Our Ref: FP/144/18/HH
Your Ref:

Town & Country Planning Act 1990 (as amended)
Town & country Planning (Development Management Procedure) (England) Order 2015
Application for Planning Permission for Works or Extension to a Dwelling

Development Replace low level side extension & conservatory with single side extension set back to allow additional parking.
Location 12 Flansham Lane Felpham

Left Hand Side Elevation

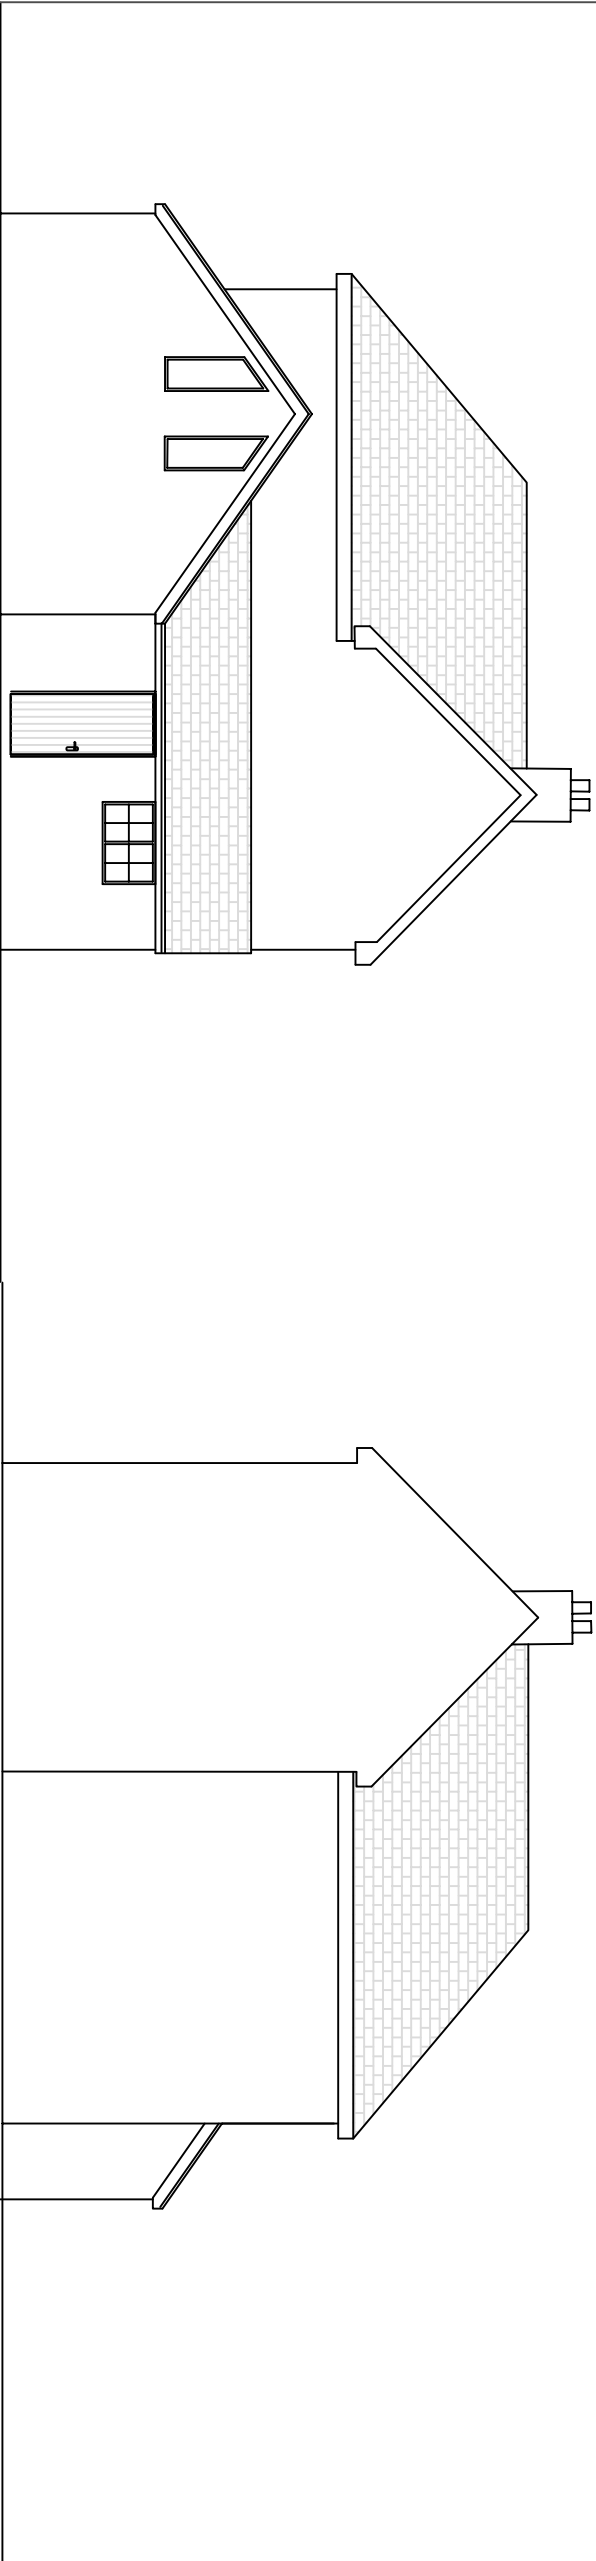
The proposed left hand side elevation indicates a window that has not been indicated on the submitted floor plan, please amend one of the drawings and submit a revised plan.

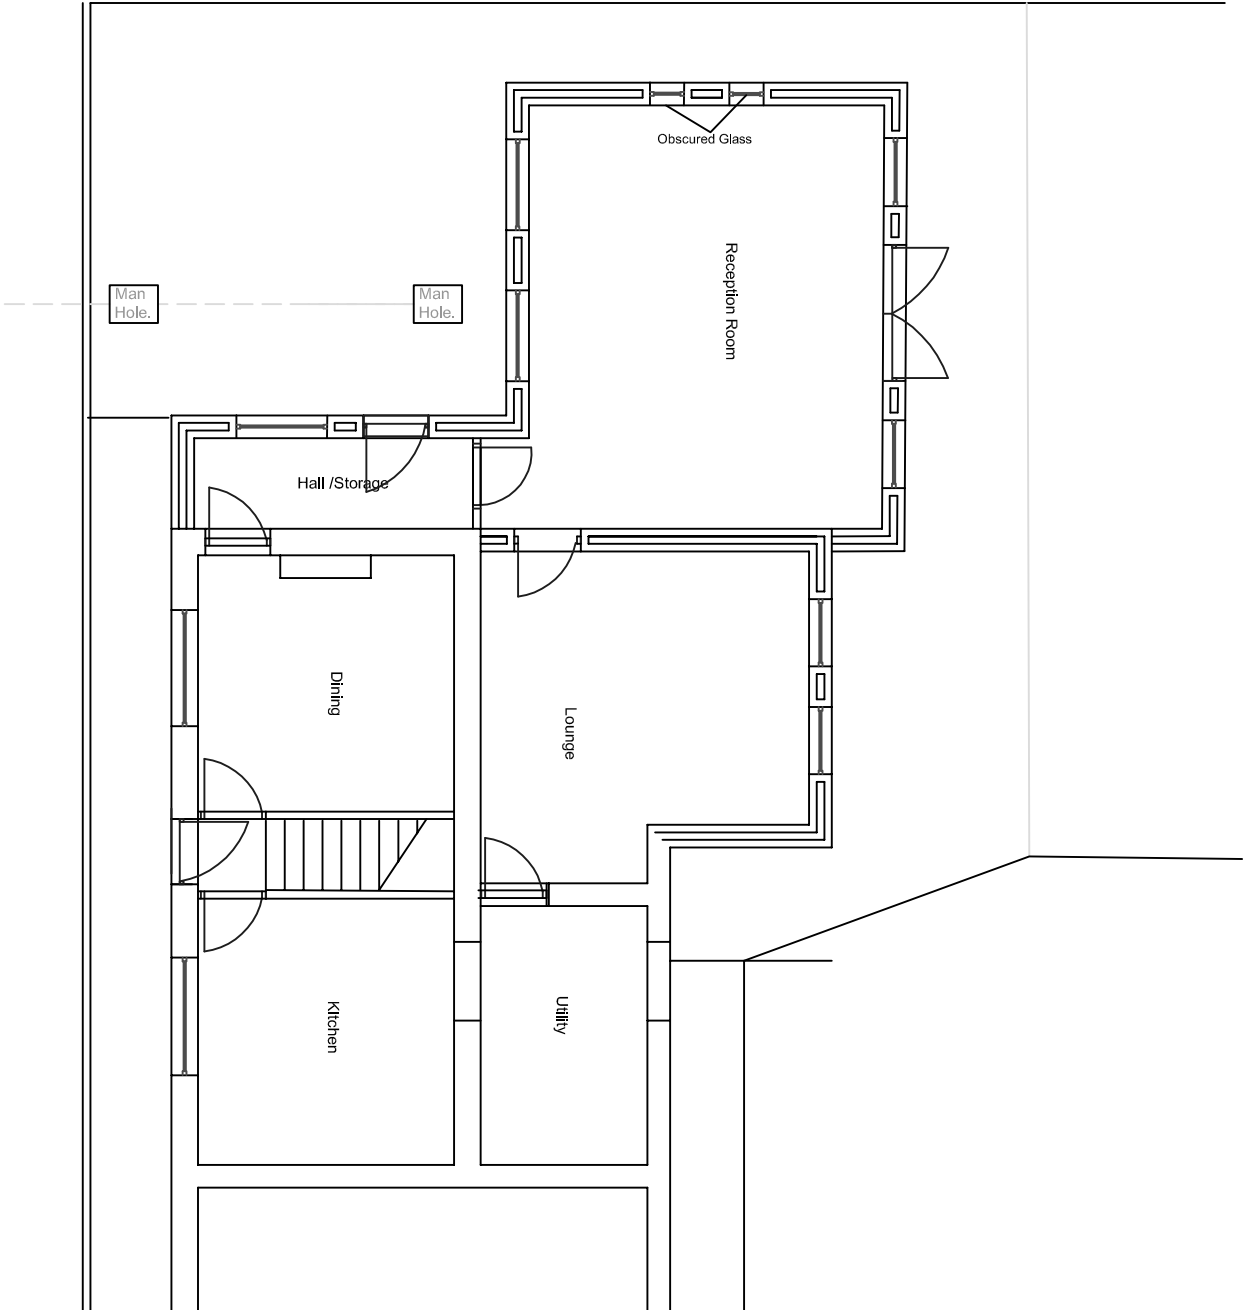
Block Plan - revised

Please submit 1 electronic or 3 paper copies of a revised block/site plan at a scale of 1:500 or 1:200 with the site dimensions indicated from the proposals to the site boundaries. Further details of what must be included on the plan can be found in the National Validation Requirements.

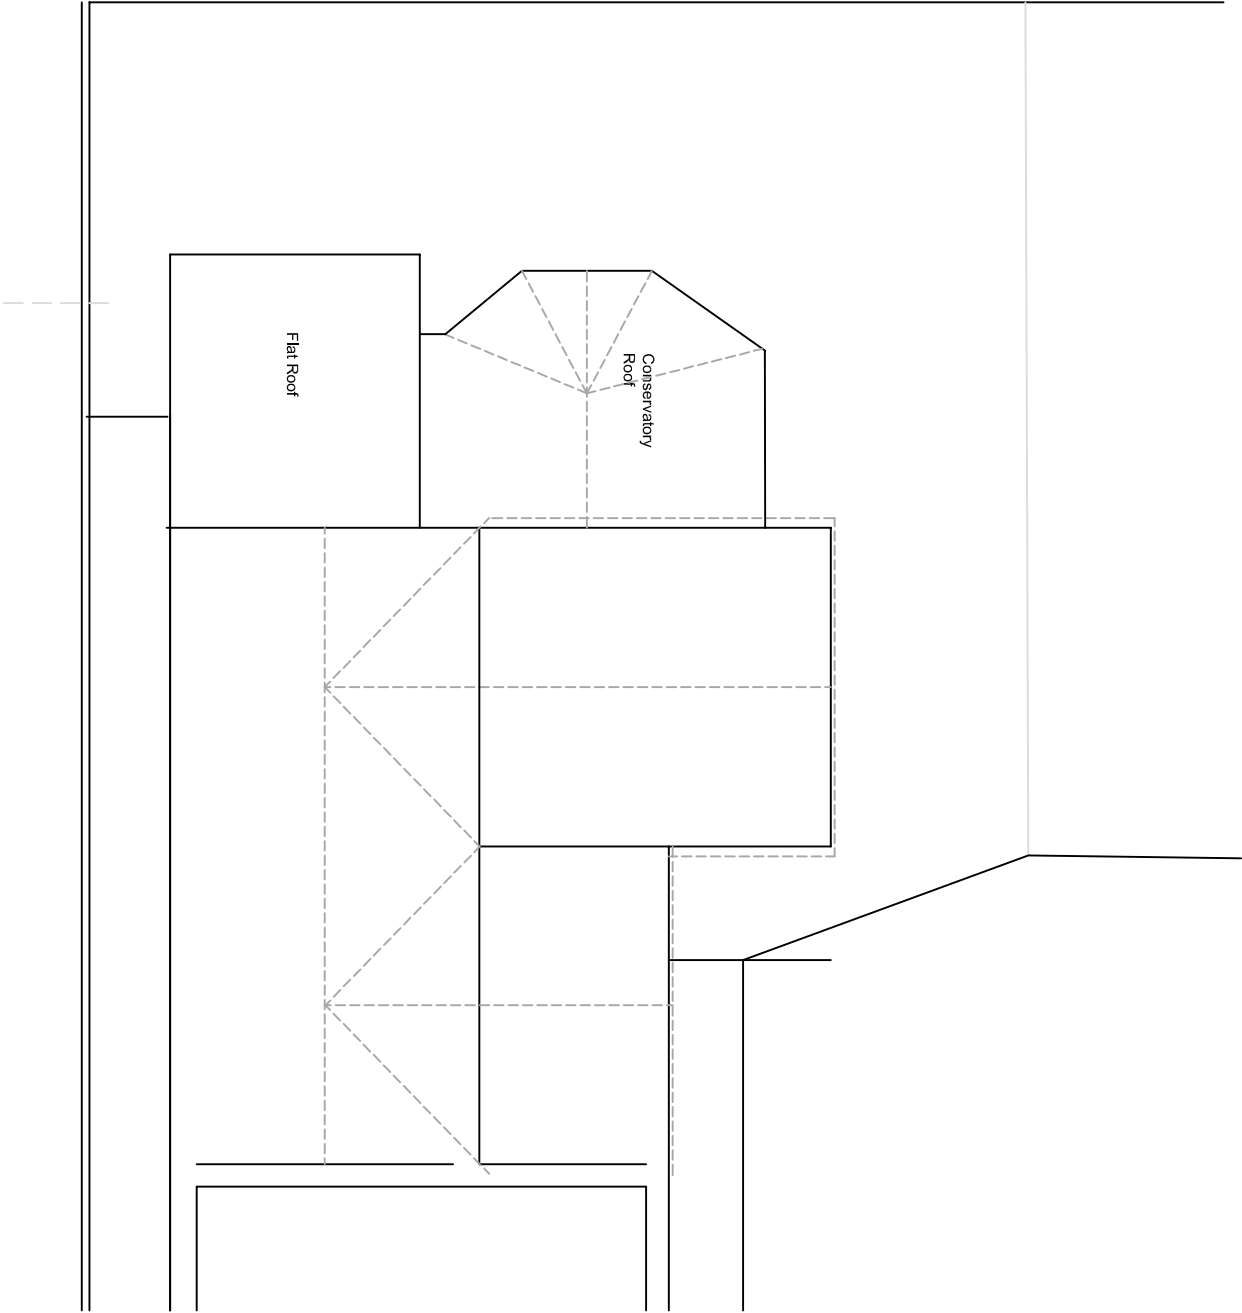
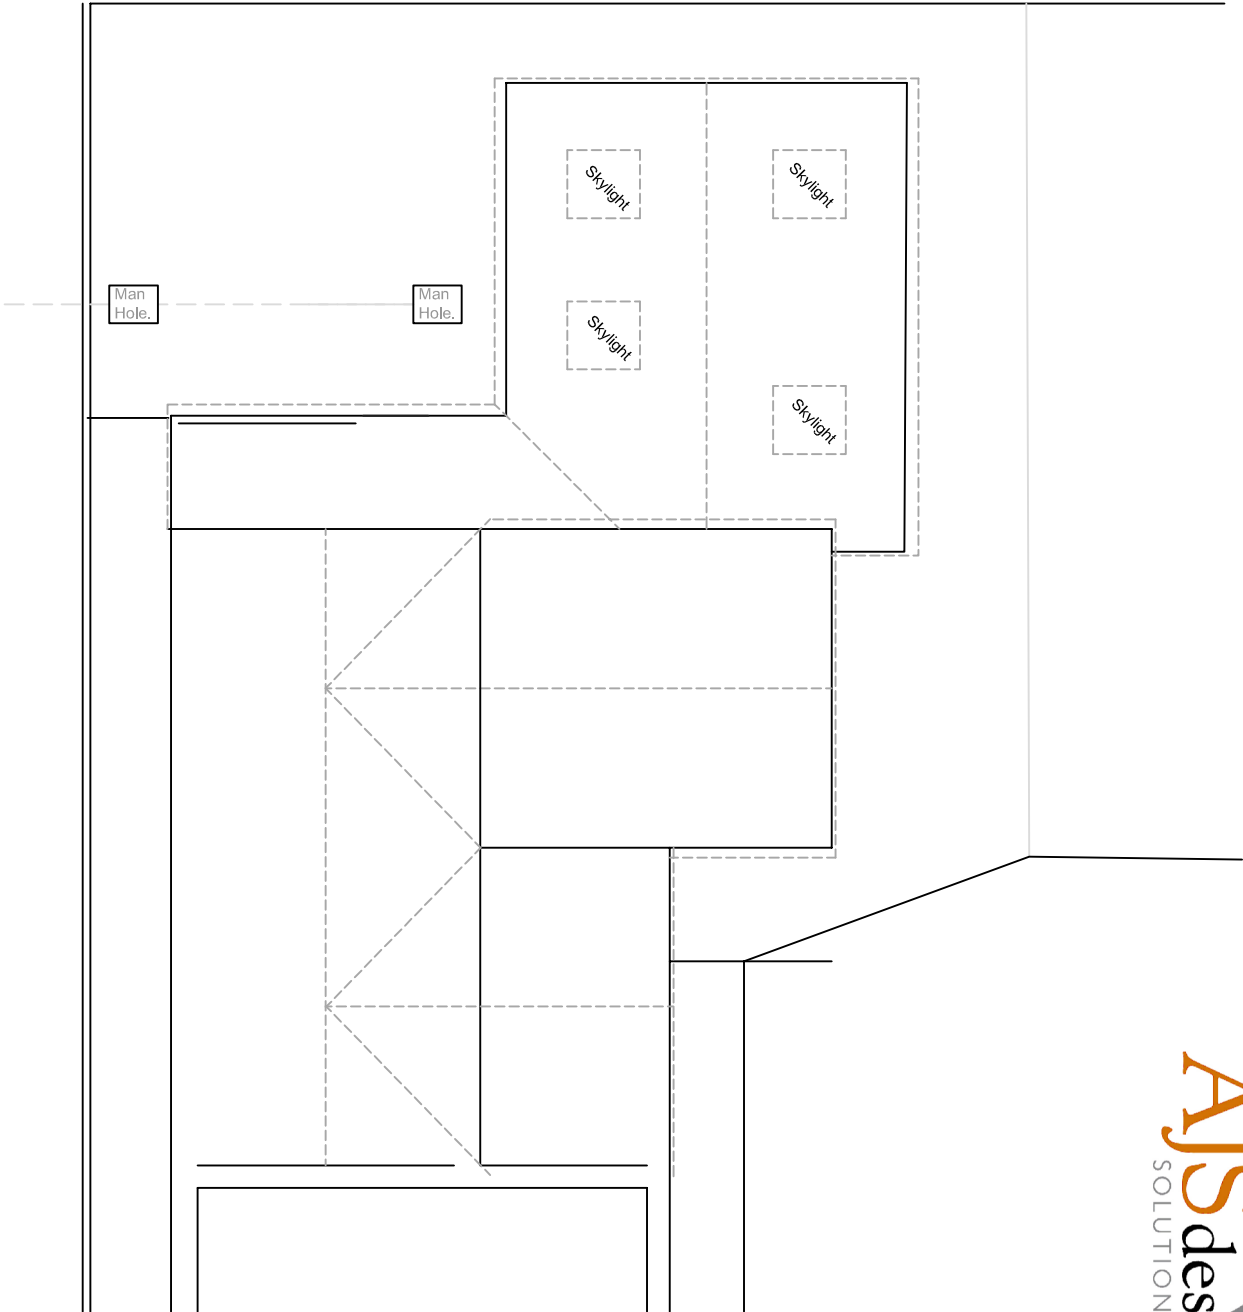
Roof Plan

Please submit 1 electronic or 3 paper copies of existing and proposed roof plan. Please refer to the National Validation Requirements for further details. Please also indicate the proposed velux windows on this drawing.
